# Comments for Planning Application 20/01575/FULL

Application Number: 20/01575/FULL

Address: 363 Ings Road Kingston Upon Hull HU7 4UY

Proposal: Erection of a single storey garage/outbuilding, built in the south-east corner of the application site (16.45m long x 9.75m wide x 4.49m high).

EAST & WEST ELEVATIONS AS PROPOSED SCALE: 1:50 @ A2 DECEMBER 2020 DRAWN: J W DRAWING NO:2465/P4/REV B

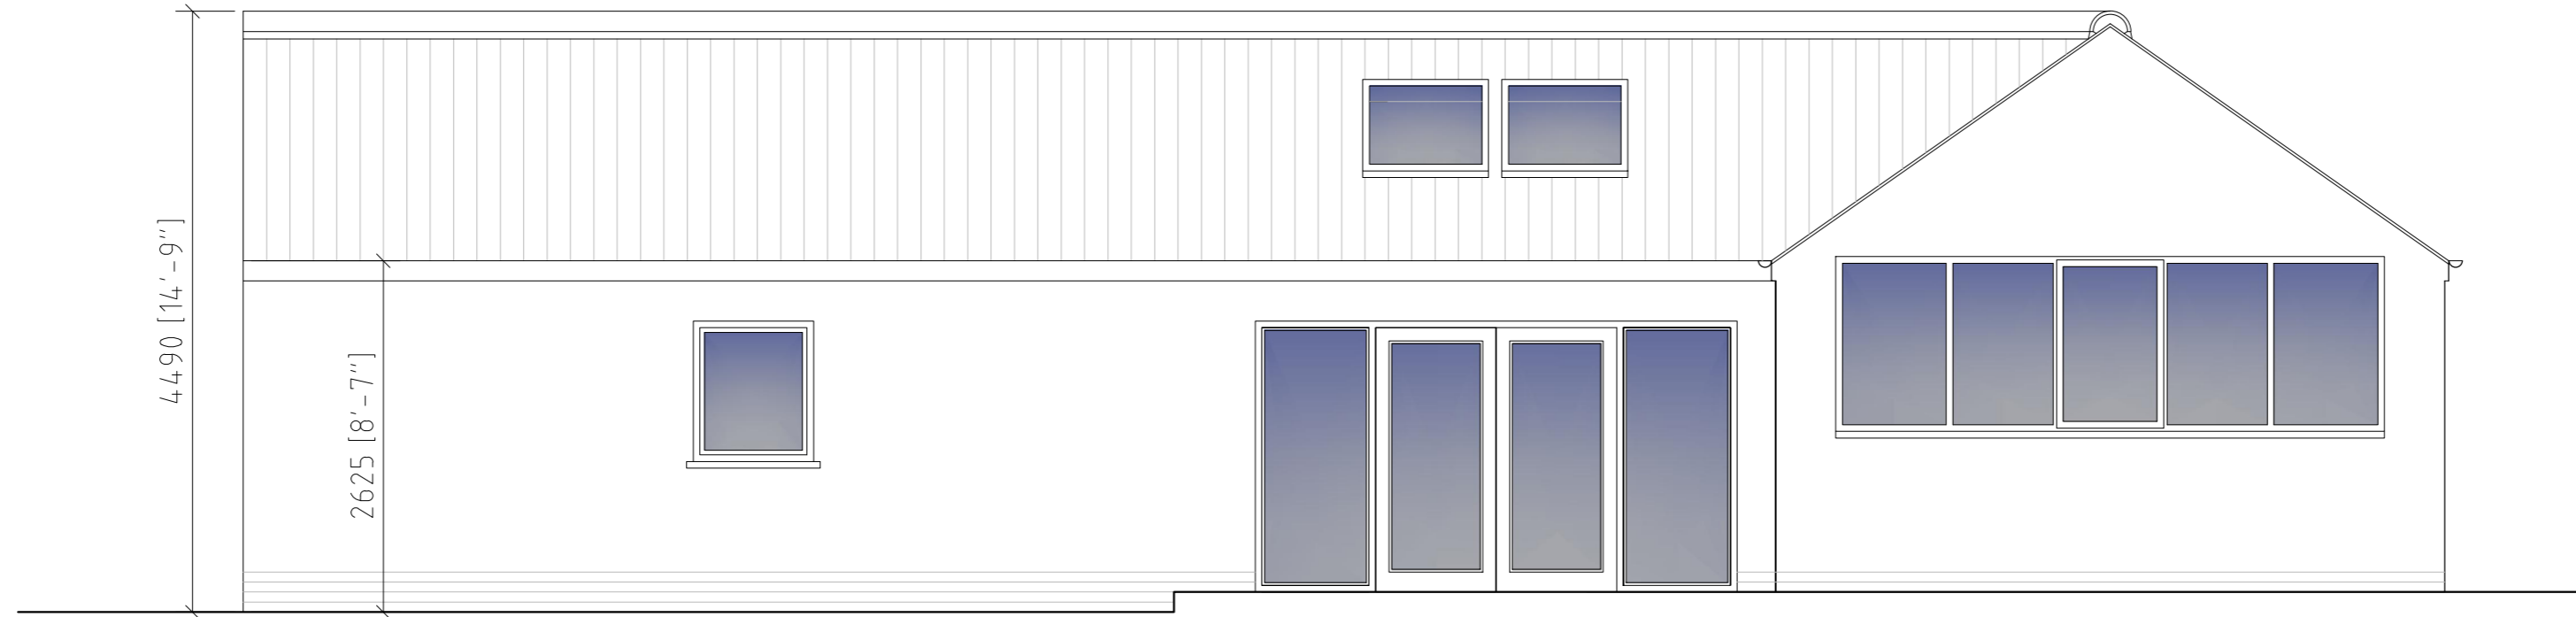
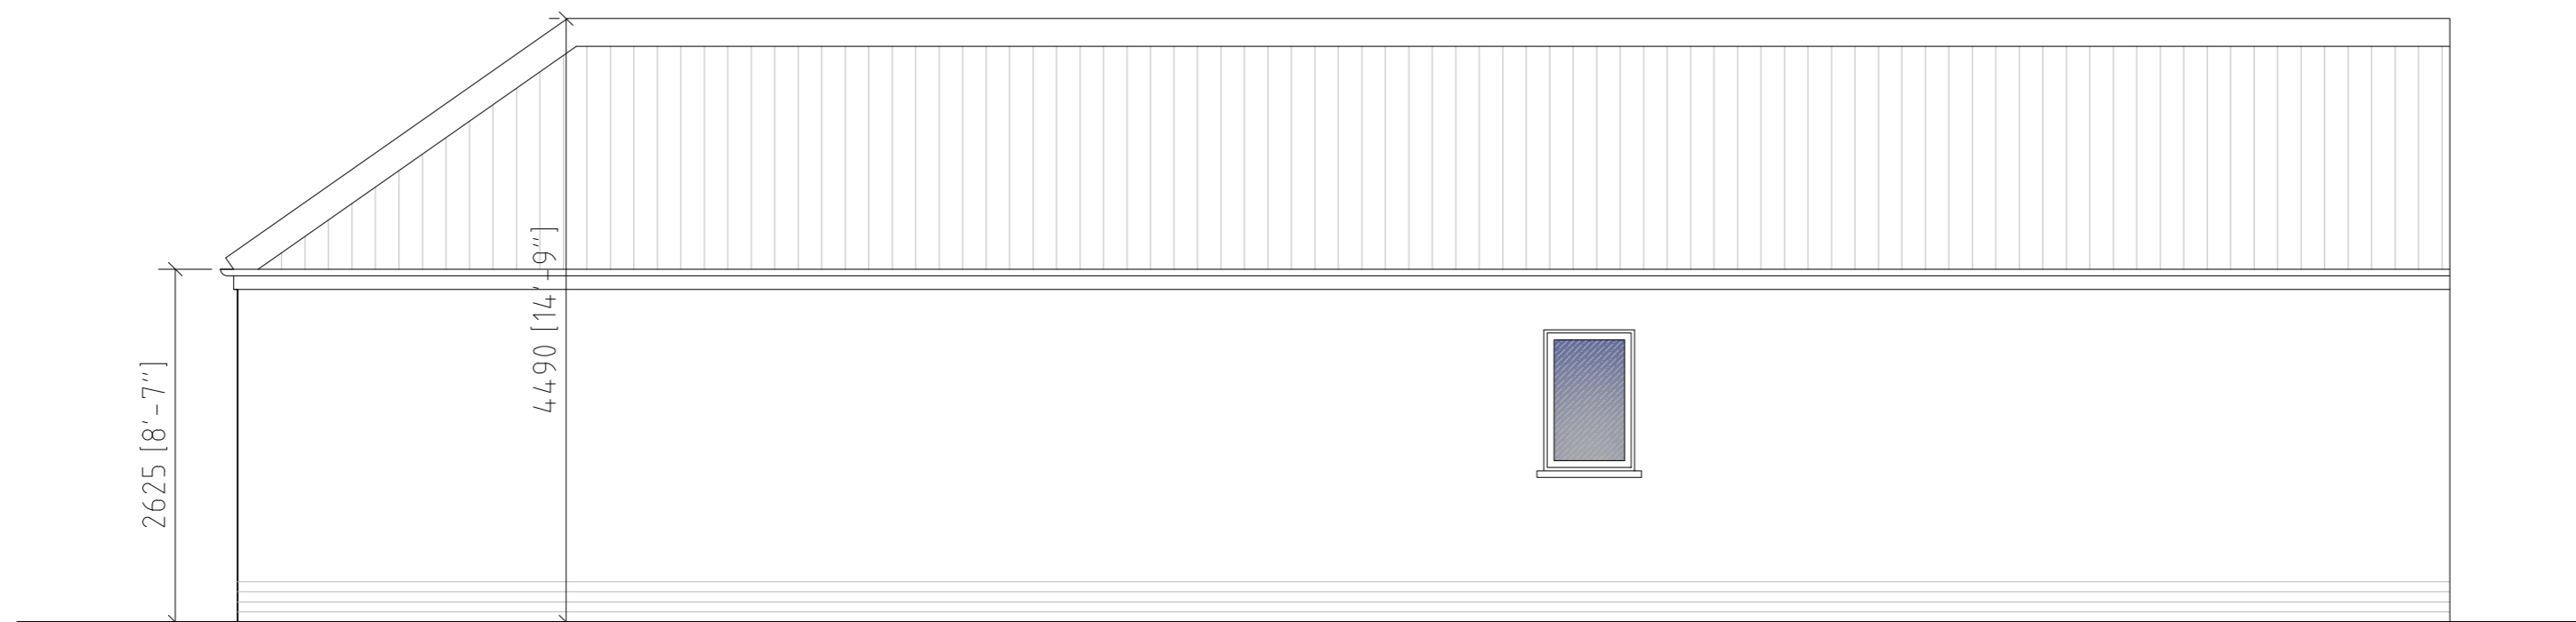
The height of the roof alone, 4.49m would mean that my garden would be totally blocked off from any direct light and no doubt any neighbouring properties would be too. A garage/outbuilding would surely not warrant a roof of this enormous size? Given that the proposer's land is higher than ours to start with, this would mean the building being even higher still on my side.

The length of the proposed building would cover the entire back of my garden, along with another 3 of my neighbours, and being of the great height proposed would severely affect our views, being that we would be staring at a brick wall and massive roof blocking all of our natural daylight, and also any sunlight. Other concerns would be the associated noise pollution that the use of this building would create, and whilst we accept noise will be around us as we are in family surroundings, this would be presumably be made far worse and more regular with such a building of this scale.

The building would dominate the view in our back garden and make us feel boxed in, being far too overbearing.

A flat roof could be a compromise which we may consider as in our opinion this would still meet the needs and purpose for the proposed building without having such detrimental effects on mine and other neighbouring properties.
